CITY OF PORTLAND BUILDING PERMIT

Located At 175 BEACH RD

Job ID: 2011-11-2595-DRG

has permission to Build shed 16' x 24' Cliff Island

SECTION A-A

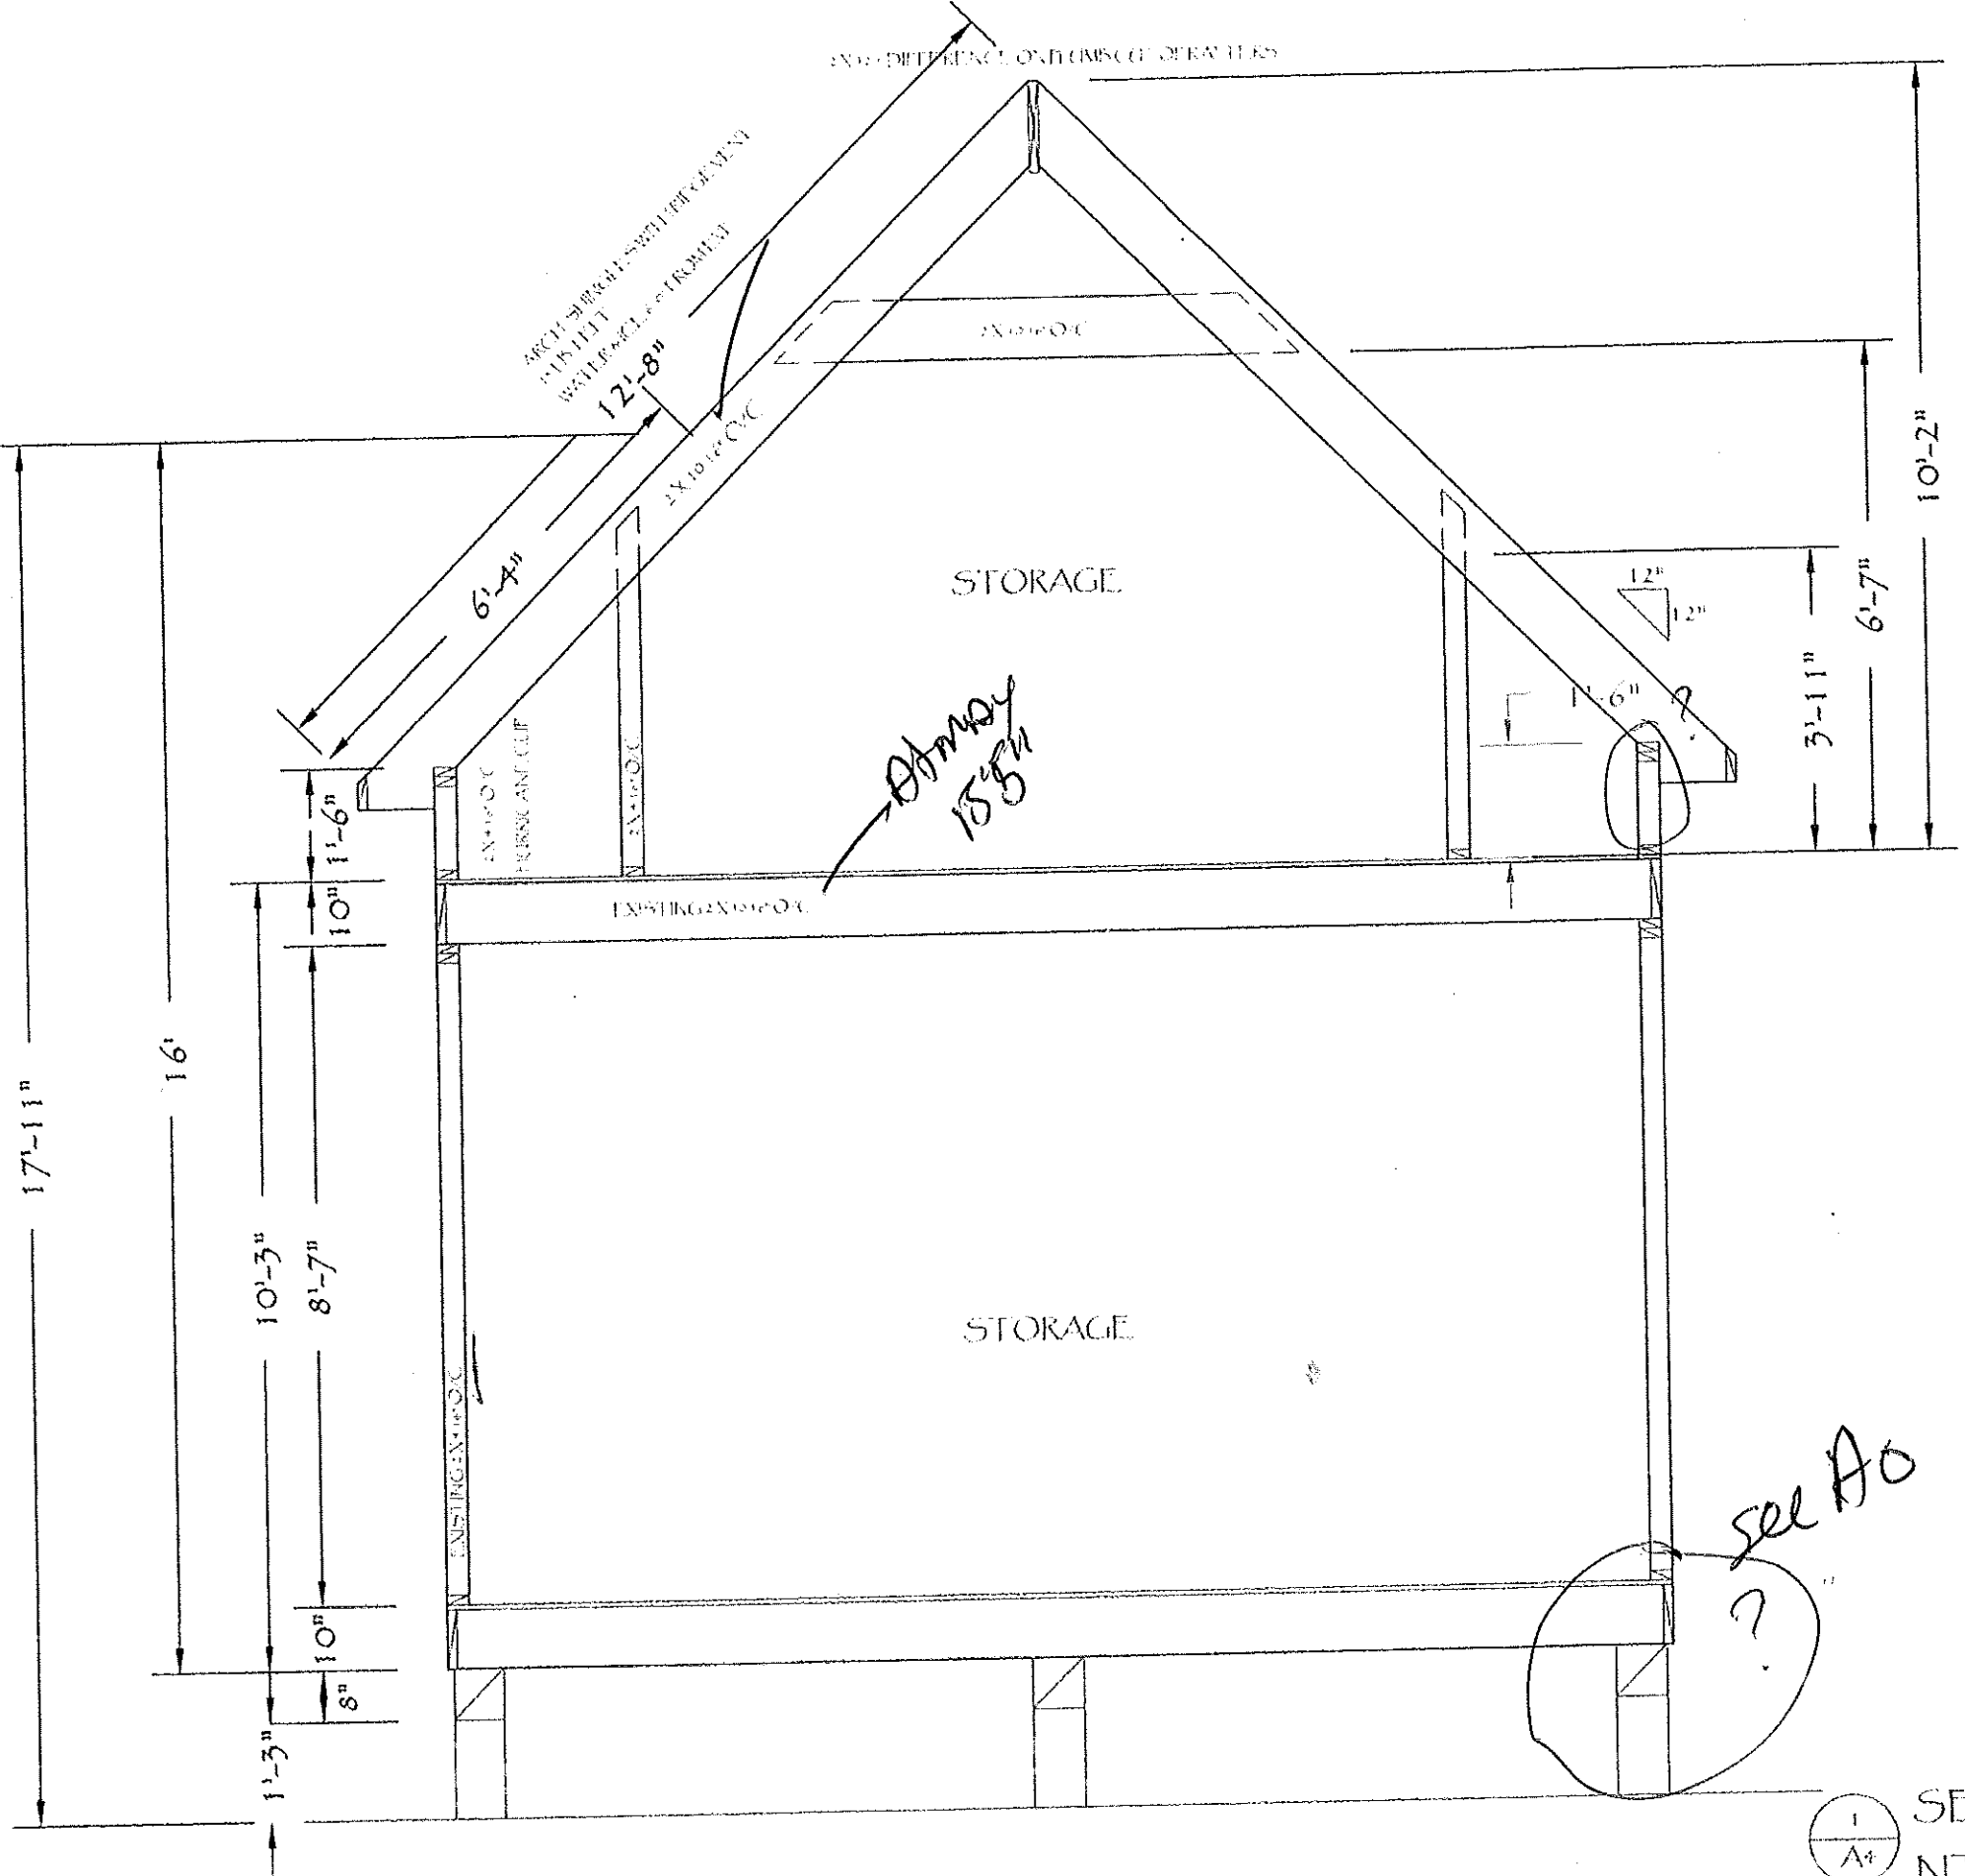
7. AS per conversation with George Trojan (Contractor) this permit is approved with the above conditions however; a new framing plan shall be submitted to this office before close-in inspection. The city will approve either a structural ridge with the 1'6" knee wall or plan approved with no knee walls with rafters resting directly on the floor.
